March 27, 2024

**Re: Daycare Norma Perez**  
**7901 Tiffany Dr. SW**  
**30-Day Temporary Certificate of Occupancy**  
**Transportation Development Final Inspection**  
Architect's Stamp dated 07-28-23 (L10-D018A)  
Certification dated 03-22-24

② Handicap Parking Sign $3/4" = 1'-0"$

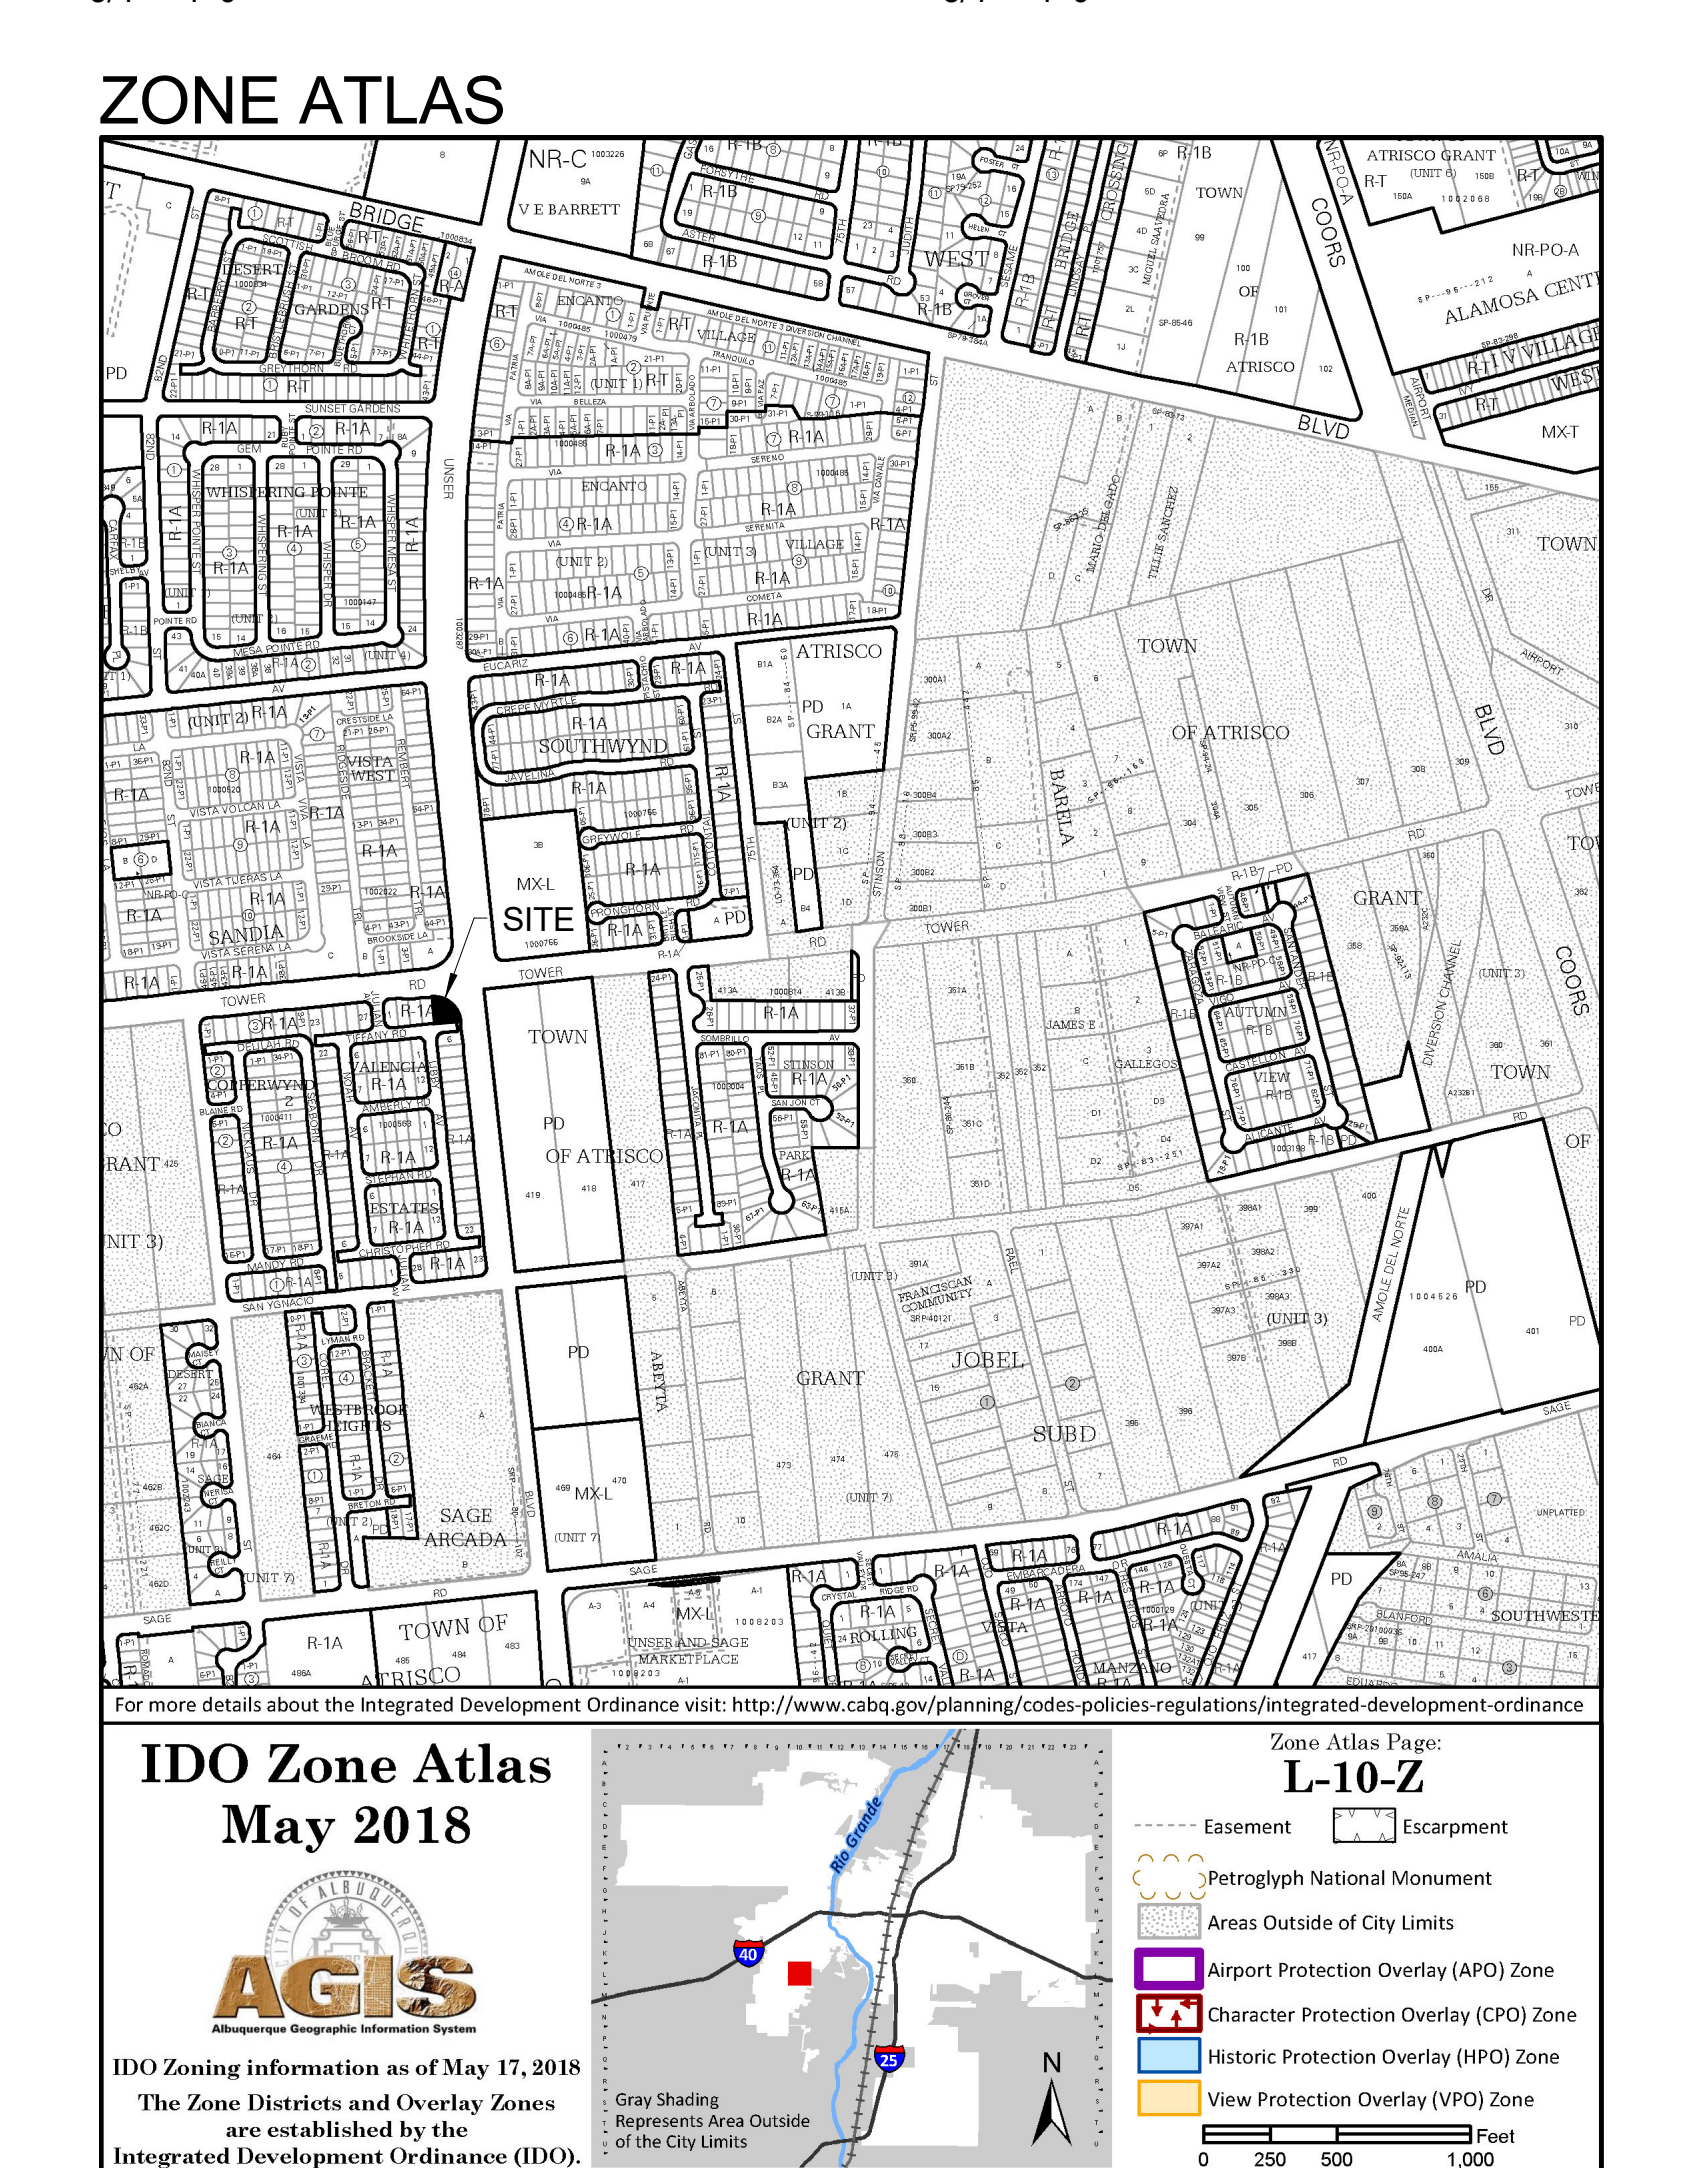
- The ADA accessible parking sign must have the required language per 66-7-352.4C NMSA 1978 **"Violators Are Subject to a Fine and/or Towing."** Please call out detail and location of signs.
- The ADA access aisles shall have the words "NO PARKING" in capital letters, each of which shall be at least one foot high and at least two inches wide, placed at the rear of the parking space so as to be close to where an adjacent vehicle's rear tire would be placed. (66-1-4.1. B NMSA 1978)
